City of Albuquerque

July 8, 2004

RE: Cottonwood Corners, Chick-Fil-A Grading and Drainage Plan
Engineer's Stamp dated 6-21-04 (A14/D7H)

RESTRICTOR DETAIL

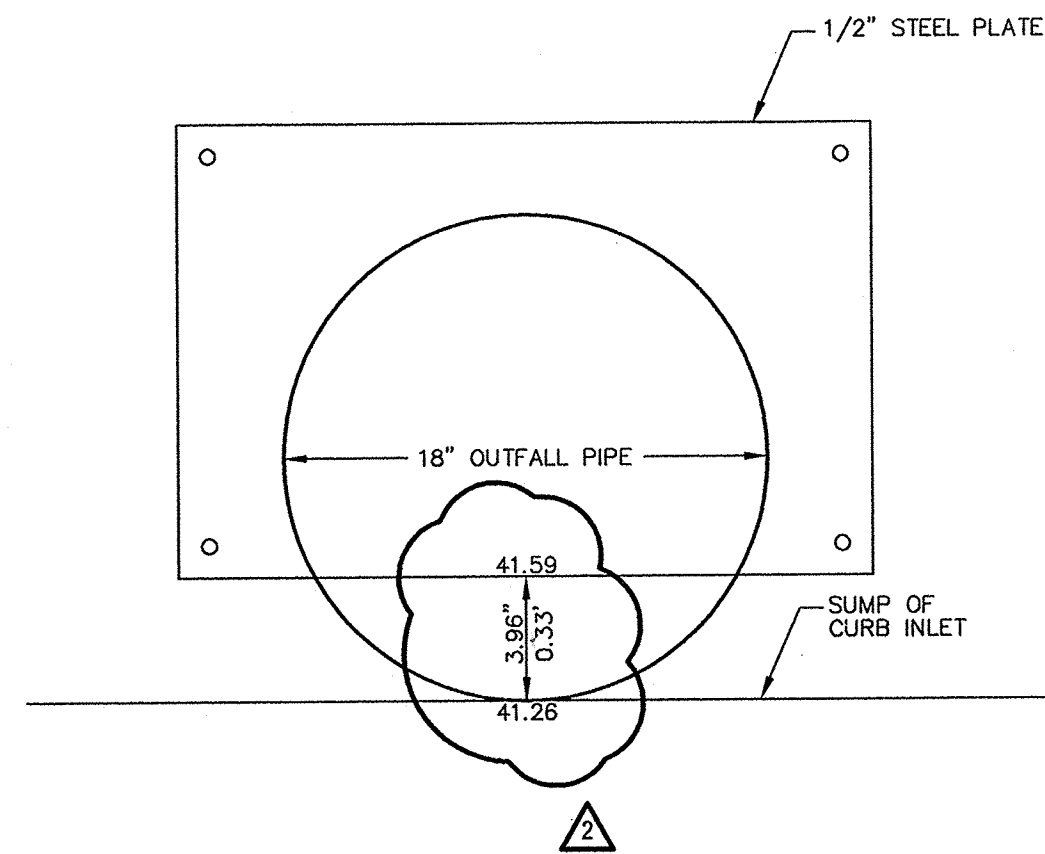
Prior to Certificate of Occupancy release, Engineer Certification per the DPM checklist will be required and the area of the orifice must be reduced to 0.083 ft^2 . This area is the result of the orifice equation, $Q=CA(2gh)^{0.5}$, given in the DPM Chapter 22, Section 3.A.2, where $Q_{\text{all}} = 0.78\text{cfs}$ (as stated by your plan), $C = 0.6$, $g = 32.2\text{ft/s}^2$, $h = 3.77\text{ft}$ ($45.13\text{ft} - 41.36\text{ft}$).
